**Reference No:** 2025/NM/93465/E

**Site Address:** Land Off, Westgate, Cleckheaton, BD19 5DR

**Description:** Non material amendment to previous permission 2021/93567 for demolition of existing commercial buildings and erection of 180 dwellings with associated works

**Proposal:** Non-material amendment to planning permission 2021/62/93567/E – demolition of existing commercial buildings and erection of 180 dwellings with associated works

Project: M3-301 BRICK AS END

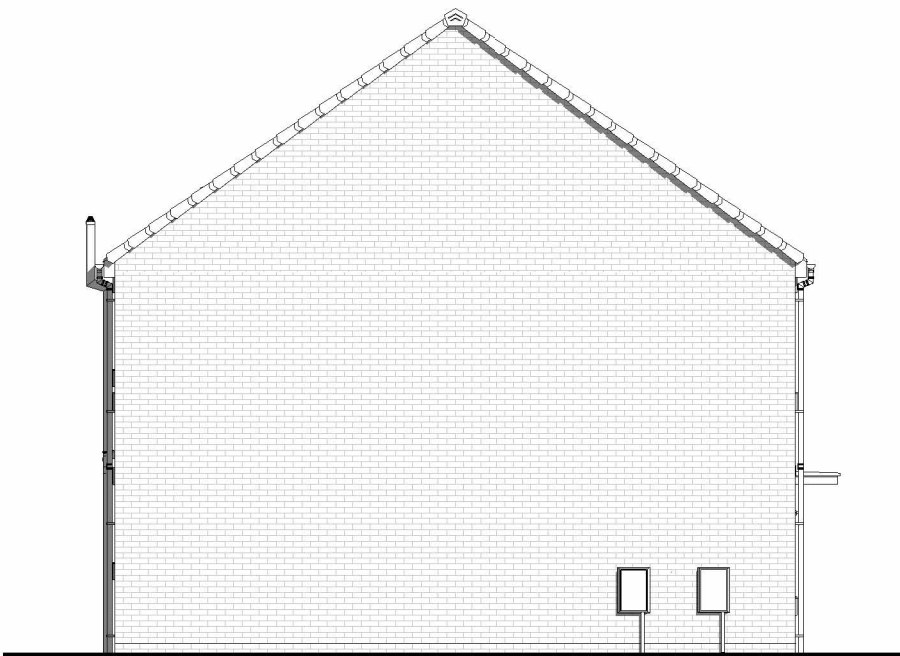
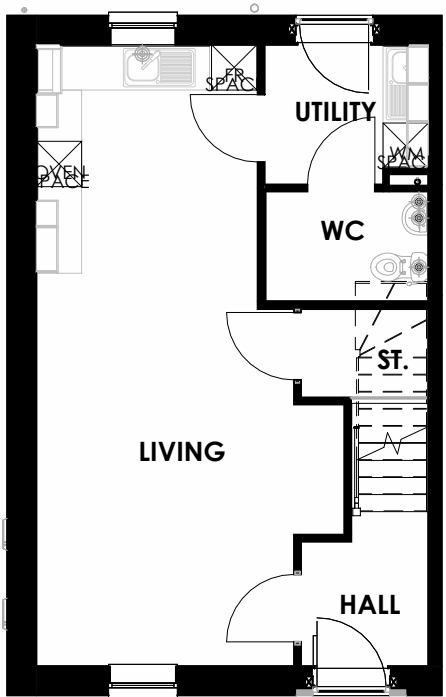
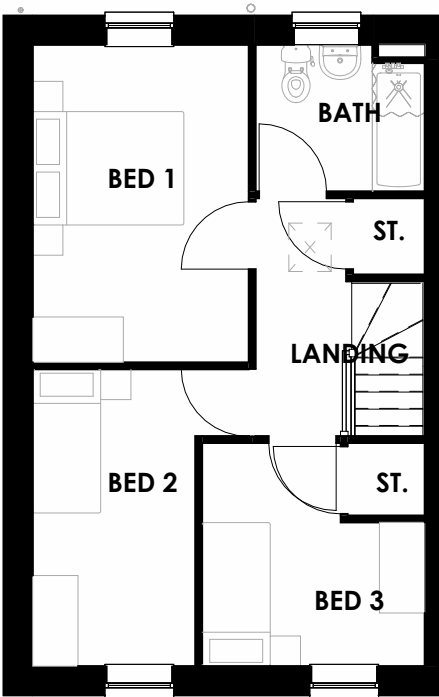
- Canopy: Additional brick detailing has been incorporated around the front door, with the addition of a Glass Reinforced Plastic canopy.
- Windows: A header brick detail has been introduced between the ground floor and first floor windows, enhancing the architectural character of the dwellings.
- Brick Detailing: A distinctive brick course detailing has been incorporated along the façades of the dwellings to provide visual interest on all elevations and improve the overall streetscape of the development.

- MY AL – 451 Planning Stone (Dwg: 101) replacing MY A-451 (Stone),
- MY AL – 451 Planning Brick (Dwg: 100) replacing MY A-451 (Brick),
- M3-301 Stone As End Planning Drawing (Dwg: 01) replacing MY A-352 (Stone),
- M3-301 Brick As End Planning Drawing (Dwg: 01 Rev B) replacing MY A-352 (Brick – Red and Buff),
- MY AL – 251 Planning Stone (Dwg: 101) replacing MY A-251 (Stone) and MY A-251 (Heads and Sills – Plots 1–4 and 179–180),

HOUSE TYPE CODE:	MY AL - 251
SCALE @A2 -	1 : 100
Drawn:	LS
Checked:	MB
Dwg No:	100

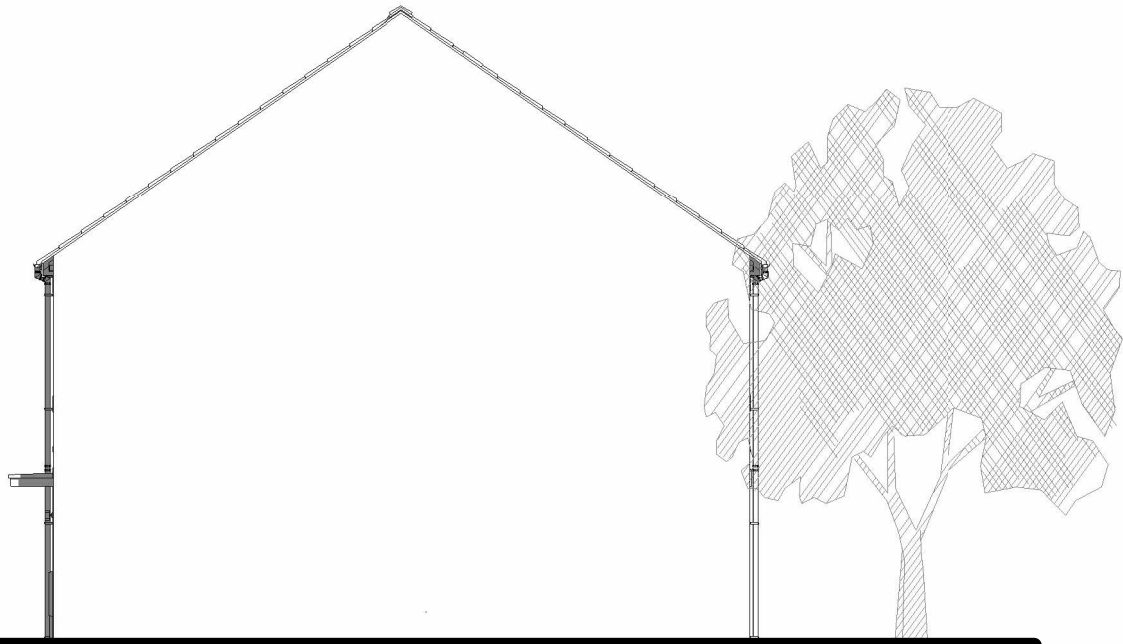
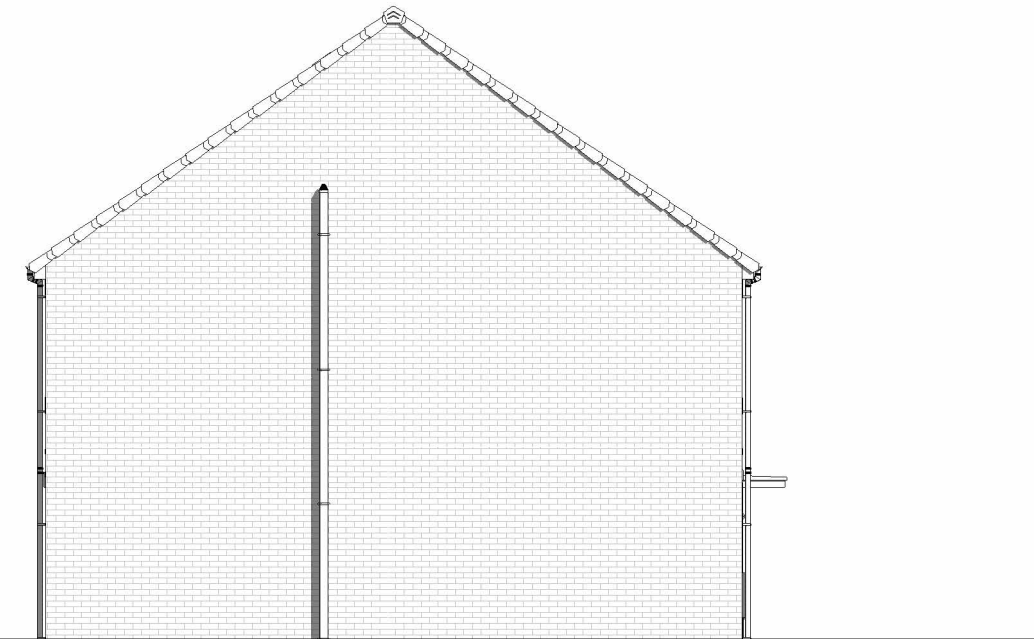
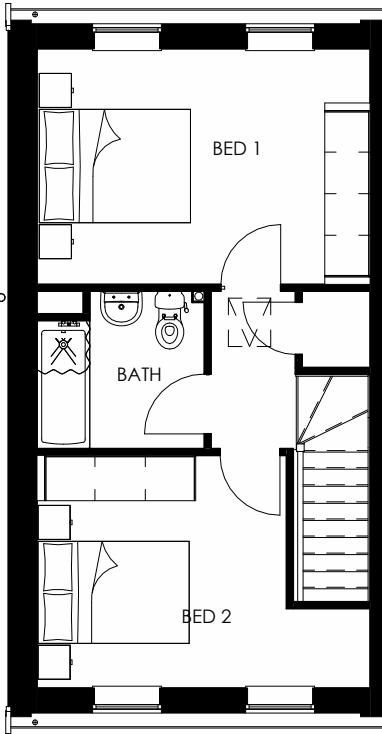
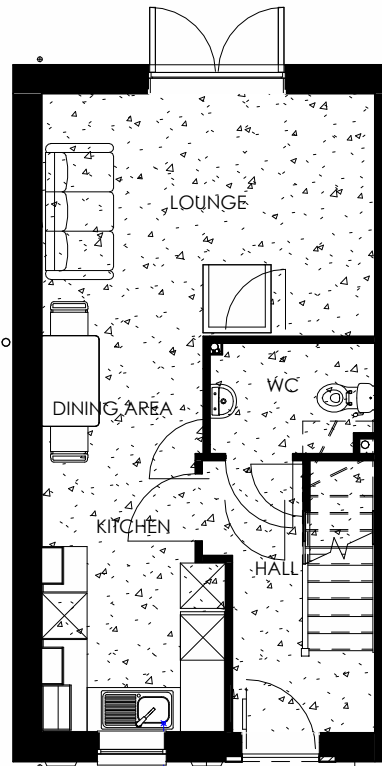
- MY AL – 251 Planning Brickwork (Dwg: 100) replacing MY A-251 (Brick – Red and Buff),
- M3-604 Stone Westgate, Cleckheaton Planning Drawing (Dwg: 01) replacing M3-601,
- HT2A – Planning Drawing (Dwg: BY00099-P1-01-A3) replacing HT2A – Planning Drawing approved under Non Material Amendment reference 2025/92574.
